An Coimisiún Pleanála
64 Marlborough Street
D01V902
DUBLIN

House on EIAR: H077

ACP: 324165

Location: Ardrah, Maughanaclea, Ballynamought, Gortloughra, Cousane, Coomclogh, Derragh, Glanycarney, Keenrath, Derrynacaheragh, Shiplough, Coolsnaghtig and other townlands Co. Cork

Figure 13-3 Topographical Landscape Features Map with identification of 'horseshoe'

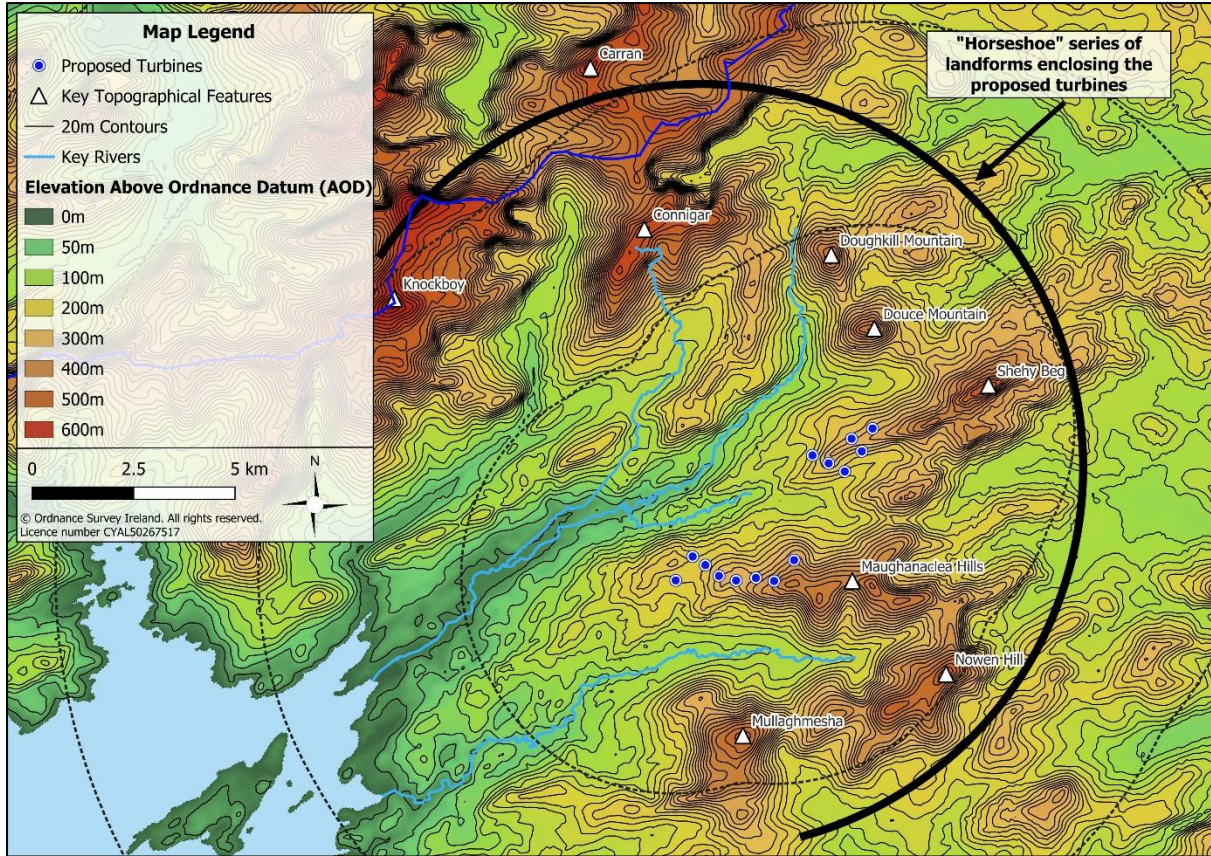
Last but not least, the land where this wind farm is planned is of a horse shoe shape. Everything resonates across our valley. You can hear people chatting when cycling from top of valley down, I can hear the geese of my neighbour far down in the distance. The sound travels a lot. So between the proximity of the turbines and the cumulation of so many in such a small space, this is causing us all a lot of concern.

Figure 13-18 Scenic Route 29 Route Screening Analysis and ZTV

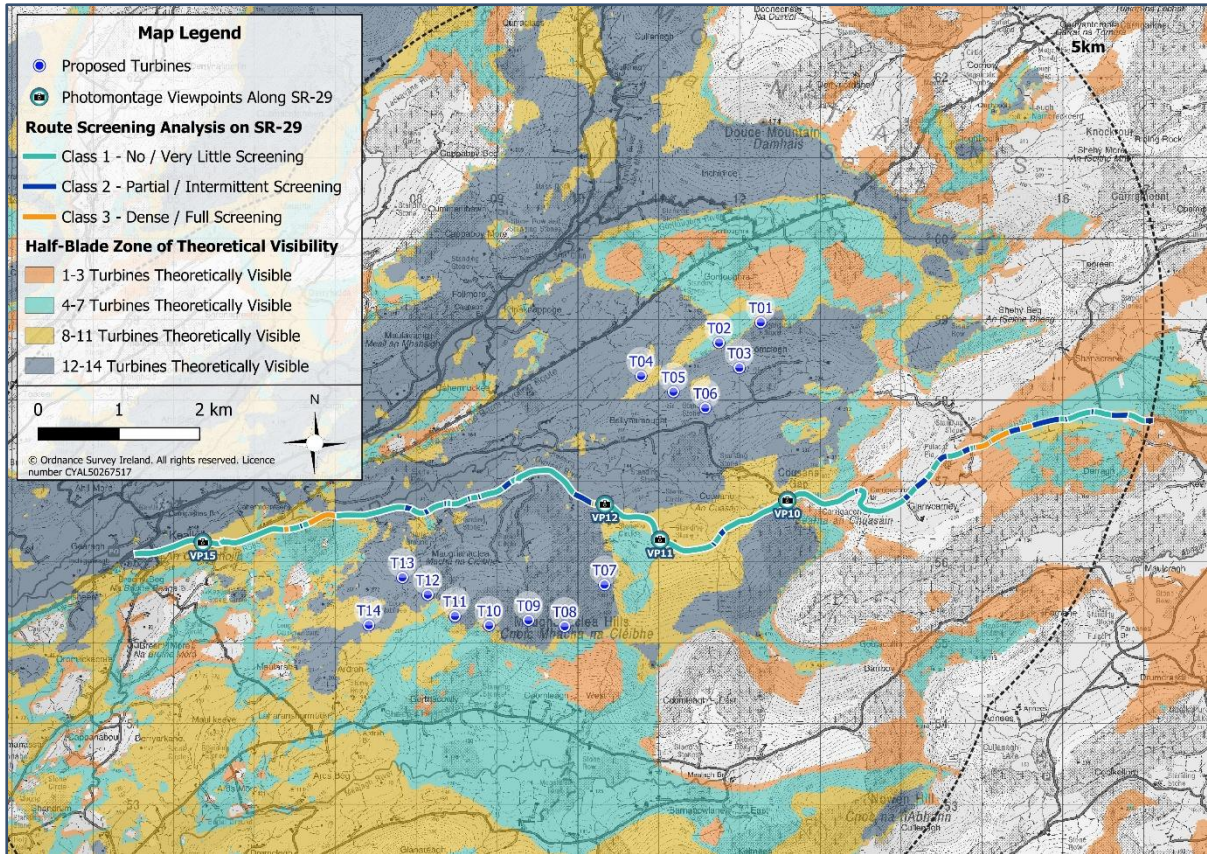
The developer fails this test completely. The R585 Regional Road is designated as Scenic Route C-SR29. MKO's own landscape assessment admits that the massive 169-metre turbines will cause a "Significant" visual effect on this exact scenic route at Viewpoints 11 and 12 in the Maughanaclea Valley. It is impossible to claim "no adverse degradation" while simultaneously classifying the visual damage to the route as "Significant."
